RE: REVIEW OF BENGALLA MINE CONTINUATION PROJECT MODIFICATION 1 - STATEMENT OF ENVIRONMENTAL EFFECTS

ATTACHMENT A: OEH REVIEW OF BENGALLA CONTINUATION PROJECT - STATEMENT OF ENVIRONMENTAL EFFECTS – SECTION 96 MODIFICATION TO SSD-5170 (MOD 1)

Figure 3.1. Vegetation communities within the Modification to Disturbance Boundary

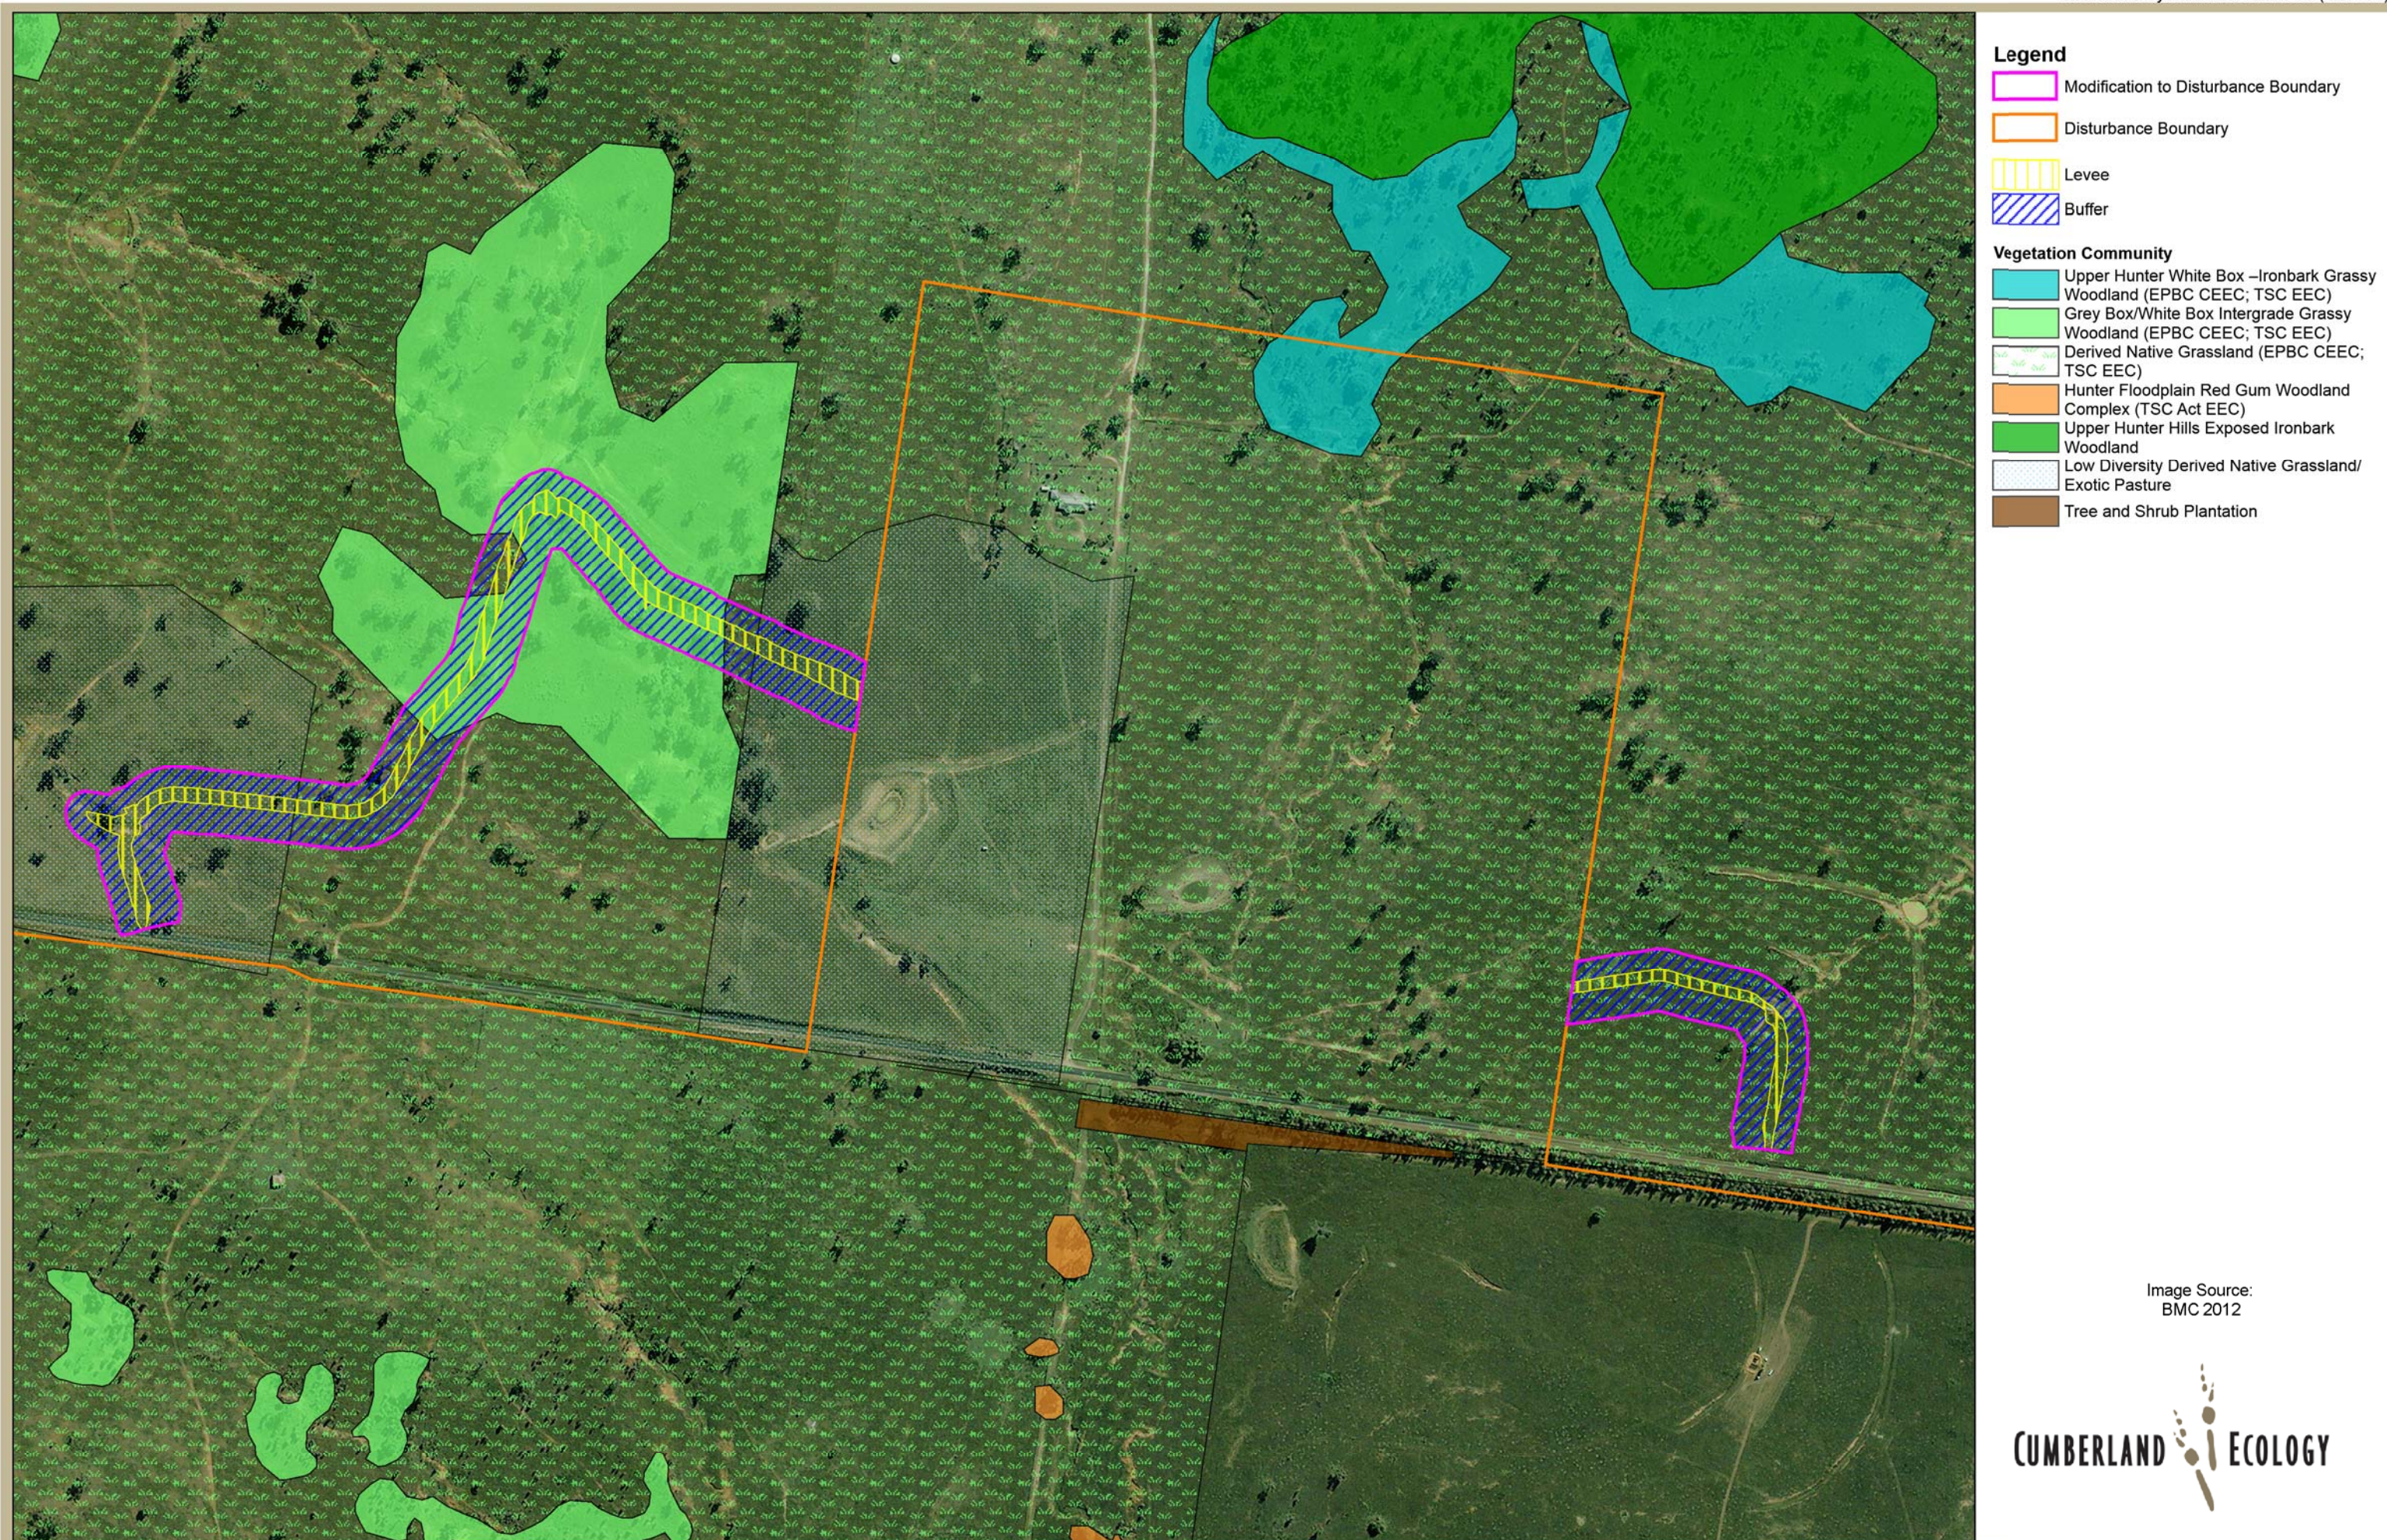
The proponent's assessment of the proposed clearing of 6.1 ha of Box-Gum Woodland EEC was considered to be 'not significant' after running the '7-part test'. This appears to be the main reason why no biodiversity offset was proposed for this modification. Instead the following three mitigation measures are proposed:

As described in the Framework for Biodiversity Assessment, there are some circumstances where a biodiversity offset is not required (Office of Environment and Heritage, 2014b: Table 4). OEH acknowledges that the scale of the impact is small, however, it is the nature and quality of the vegetation and threatened species habitat effected that determines offsetting obligations. However, in this instance all available data shows that an offset will be required. As such OEH would have expected the SEE to address the provision of biodiversity offsets and/or compensatory measures under Section 6 'Impacts, Management and Mitigation' and Chapter 5 of the Ecology Study.

OEH notes that the proposed impact area (both clearing and buffer zone) on vegetation is approximately 9 ha of vegetation (including about 6.1 ha of Box-Gum Woodland). This generated approximately 139 ecosystem credits. The current market value of ecosystem credits in the Hunter Region is around \$2,000 per credit and as such the biodiversity value of the 9 ha of native vegetation to be removed is in the order of \$278,000. OEH recommends that the proponent should either retire the appropriate biodiversity credits or provide appropriate supplementary measures, equivalent to the biodiversity value that is being lost, to either a site specific environmental project that benefits threatened species or towards an action(s) that benefits a likely potential threatened species (as listed under OEH's 'Saving Our Species' program) (Office of Environment and Heritage, 2014a). To determine the exact number of biodiversity credits the proposed impact area would generate, OEH recommends that the proposal be assessed under the BioBanking Assessment Methodology (Office of Environment and Heritage 2014c) using the full complement of required data collected from the site. If the proponent does not wish to undertake such an initiative then OEH would expect a suitable biodiversity offset (commensurate to the impact site) be set aside and managed in perpetuity under one of the following conservation mechanisms:

- the establishment of BioBanking sites with BioBanking agreements under the *Threatened Species Conservation Act 1995*
- the dedication of land under the *National Parks and Wildlife Act 1974*
- a Trust Agreement under the *Nature Conservation Trust Act 2001*
- a Planning Agreement under s93F of the *Environmental Assessment and Planning Act 1979*.
